MORGAN AND MORECAMBE OFFSHORE WIND FARMS: TRANSMISSION ASSETS

Response to Section 51 advice

December 2024

Document reference: S_S51_1

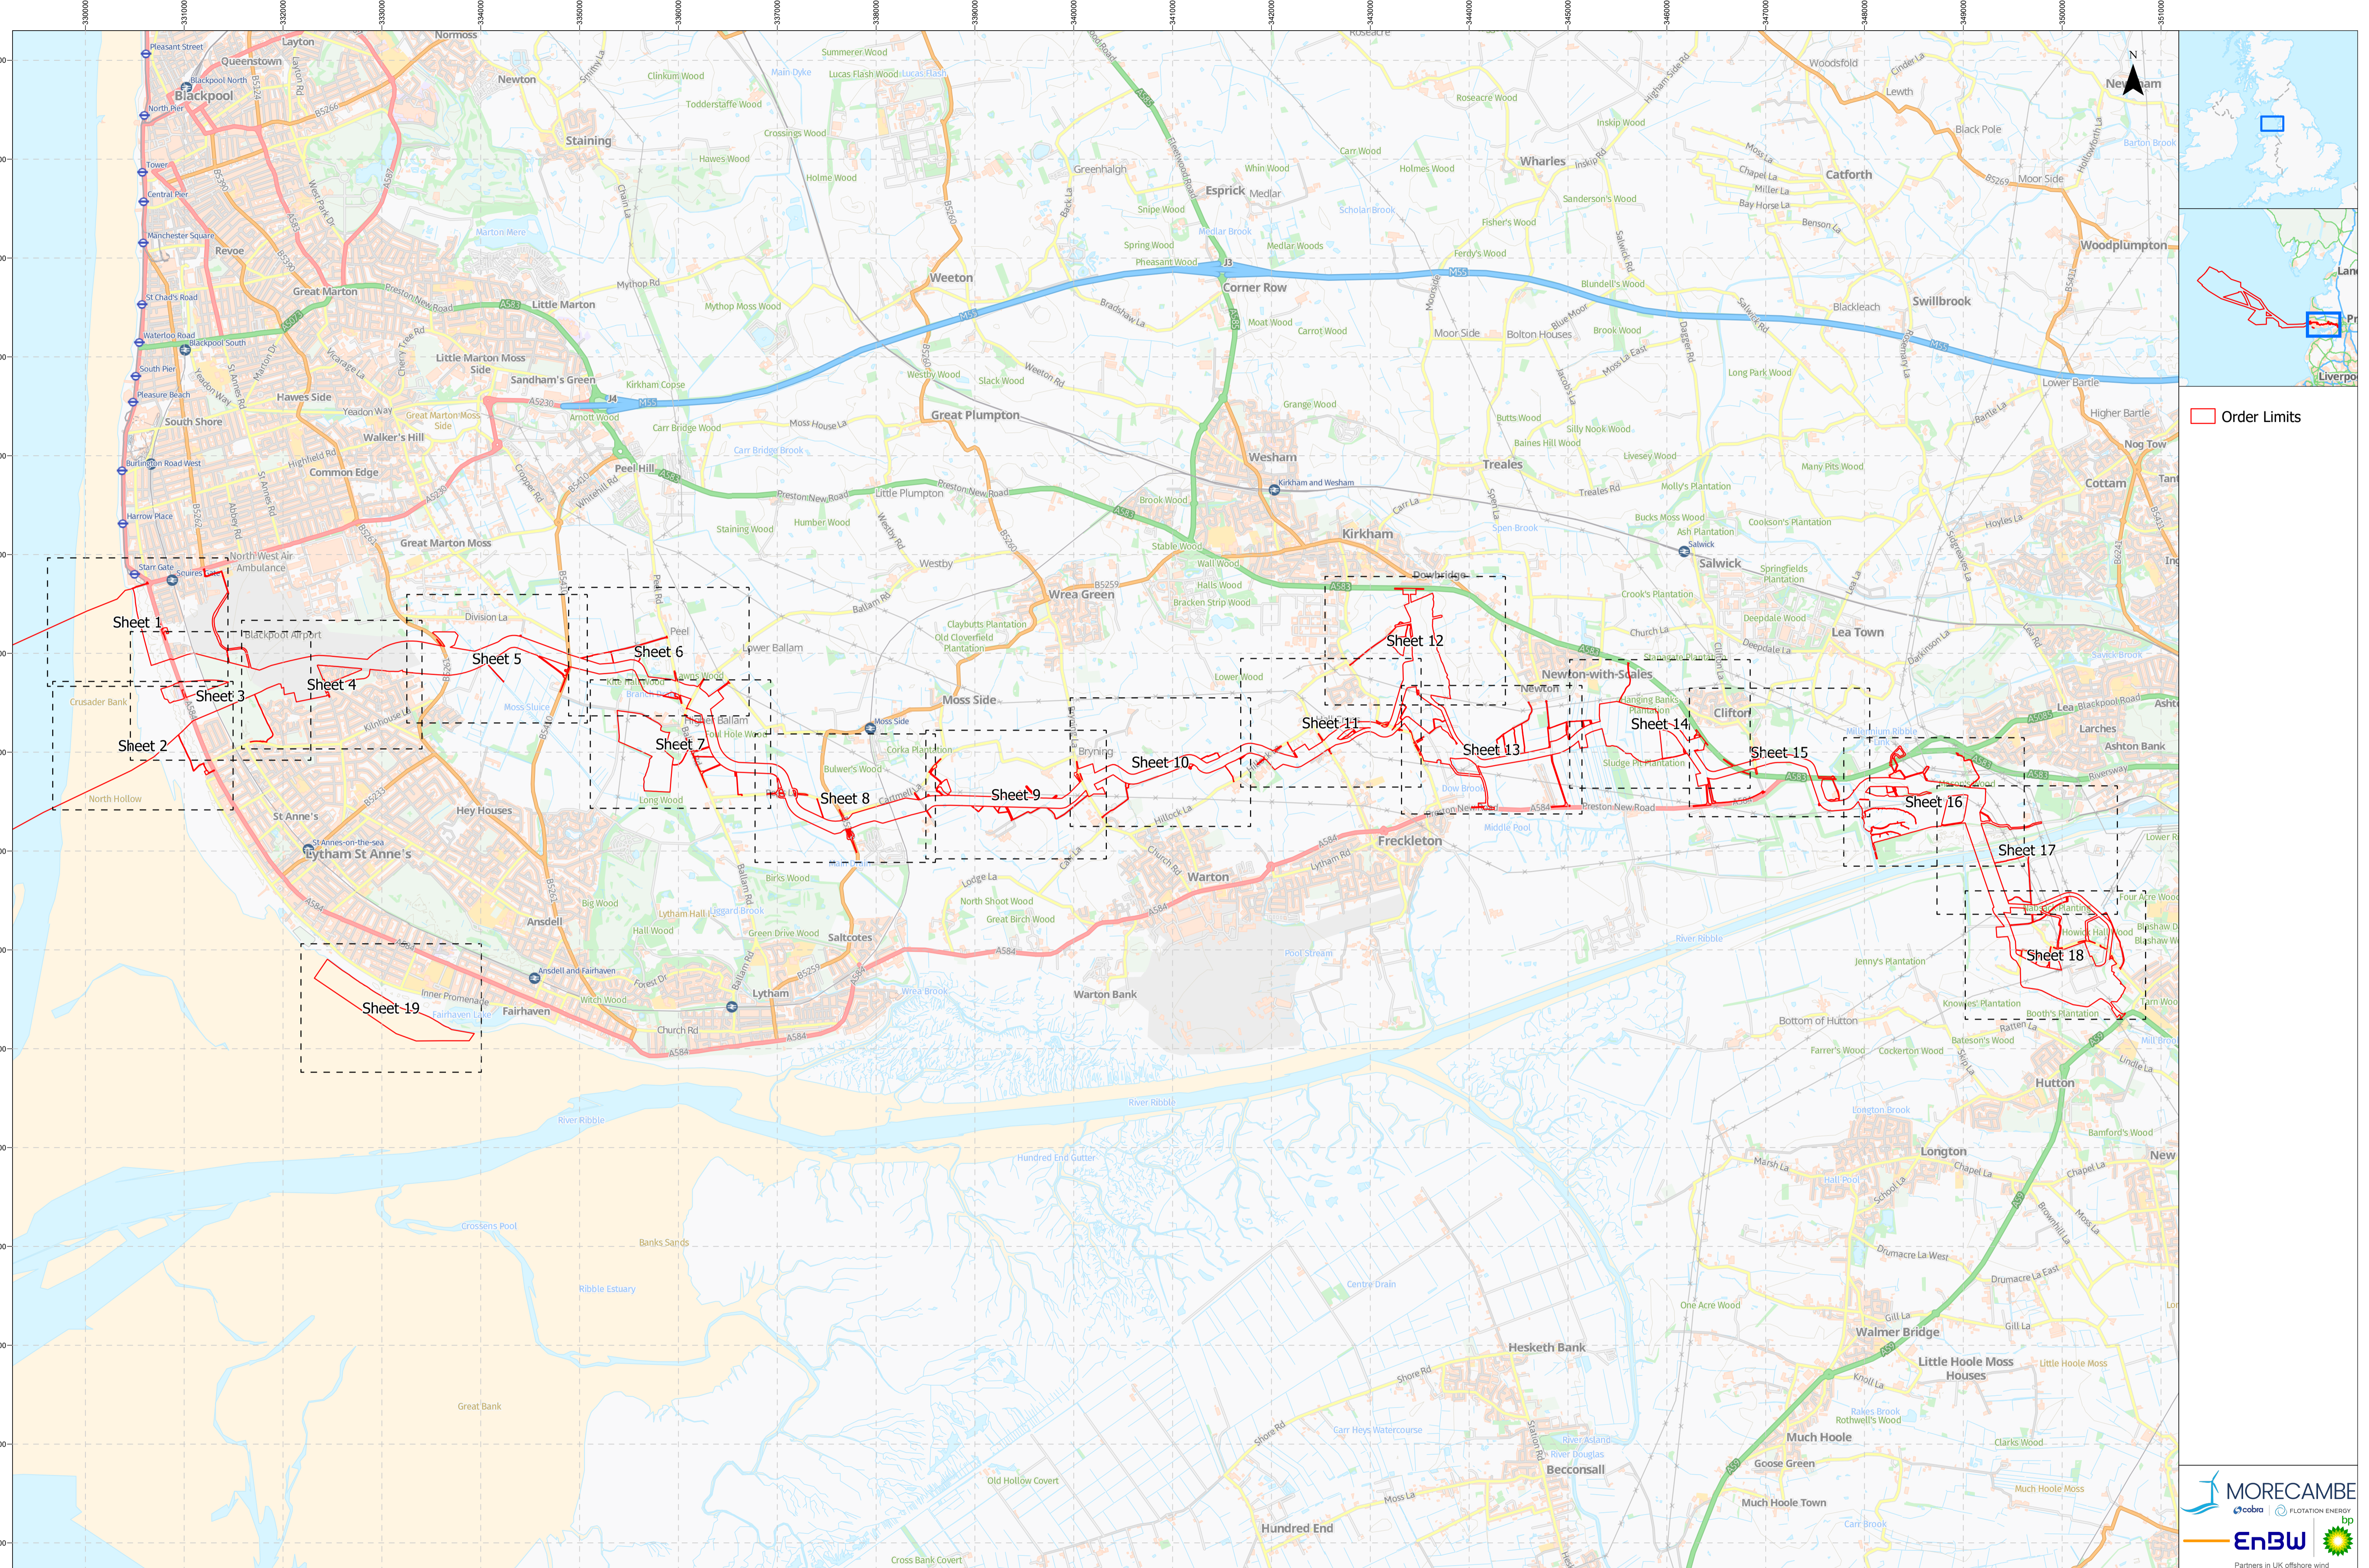
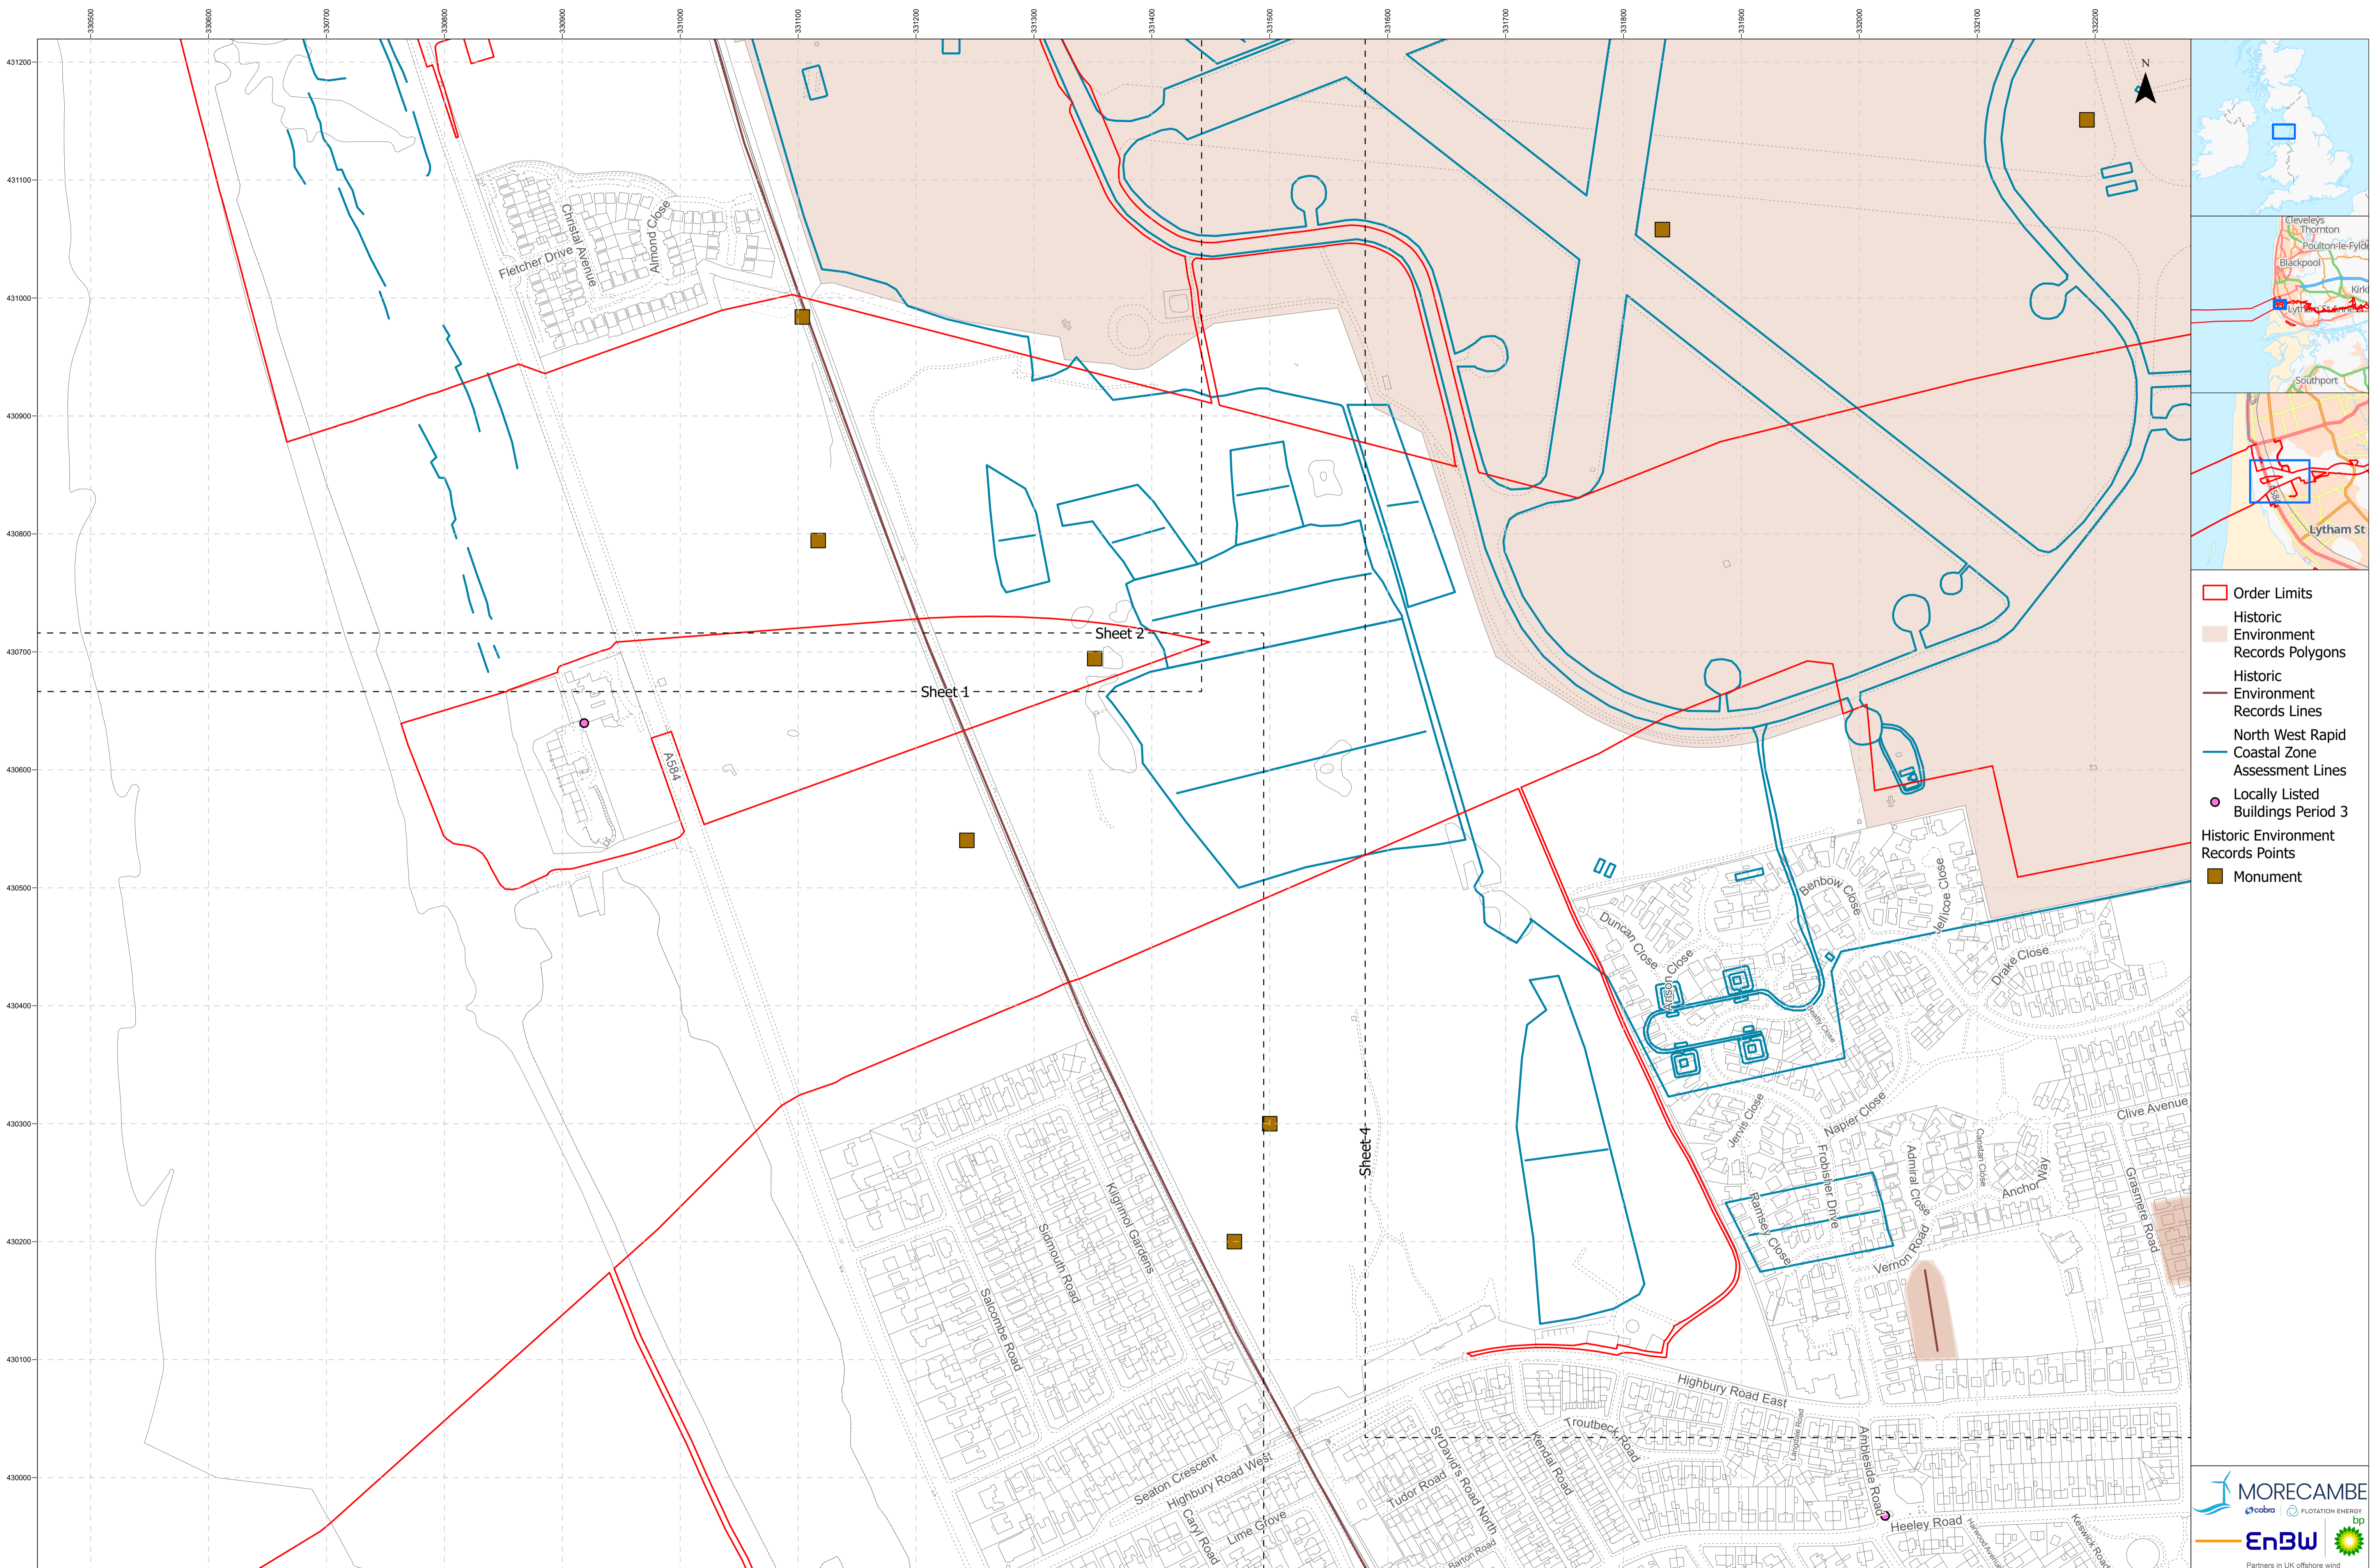
Onshore Statutory and Non-Statutory Nature Sites and Onshore Historic or Scheduled Monument Sites	<p>“The plans showing Onshore Statutory and Non-Statutory Nature Sites (and Waterbodies in a River Basin Management Plan) (Doc B14) and Onshore Historic or Scheduled Monument Sites (Doc B16) present the sites, rivers or historic assets, however these are not labelled (unlike the equivalent offshore plans). The Applicants are advised to provide an updated set of figures with appropriate labelling of the features being represented. “</p>	<p>The Applicants have updated this document with the requested changes and have submitted it to the Planning Inspectorate (document reference: B14/F02 and B16/F02). Both documents contain a Schedule of Changes.</p>
Onshore Historic or Scheduled Monument Sites	<p>Between the onshore historic or scheduled monument sites (Doc B16) and ES Volume 3 (Doc F3.12, figures for chapter 5), there appear to be some minor differences in terms of the specific assets recorded between these drawings. An example is Doc F3.12 ES figure 5.7 compared to sheet 3 of Doc B16. The Applicants are advised to provide an updated set of figures which are consistent in the features being represented, with appropriate labelling.</p>	<p>The Applicants have reviewed the Onshore Historic or Scheduled Monument Sites plan alongside the Environmental Statement (ES) Volume 3 Figures and can confirm that the data included is the same. However, the data shown on the ES figures has been separated based on the time period for the records. To facilitate ease of cross-referencing between the documents, labels referencing the heritage asset list entry have been added to the Onshore Historic or Scheduled Monument Sites plan (document reference: B16/F02). The Applicants have submitted the updated Onshore Historic or Scheduled Monument Sites plan (document</p>

Topic	Section 51 advice	Applicants' response
		reference: B16/F02) to the Planning Inspectorate. The document also contains a Schedule of Changes.
Statutory and Non-Statutory Features of (The Offshore) Historic Environment Plan	<p>“Standalone figure B17 (Statutory and Non-Statutory Features of (The Offshore) Historic Environment Plan) only shows offshore exclusion areas rather than specific features, however the specific sites are shown on the ES figures. The Applicants are advised to provide an updated set of figures with appropriate labelling of the features being represented.”</p>	<p>The Applicants have reviewed the Offshore Historic Environment Plan alongside the ES Volume 2, Figure 8.5 and can confirm that the location of the geophysical anomalies shown as high medium and low are the same.</p> <p>The Applicants have reviewed the Offshore Historic Environment Plan alongside the ES Volume 2, Figure 8.6 and can confirm that Archaeology Exclusion Zone (AEZs) and Temporary Archaeology Exclusion Zones (TAEZs) are the same. To enable cross-referencing between the documents, named wrecks have been added to their corresponding ID reference. The Applicants have submitted the updated Offshore Historic Environment Plan (document reference: B17/F02) to the Planning Inspectorate. The document also contains a Schedule of Changes.</p>
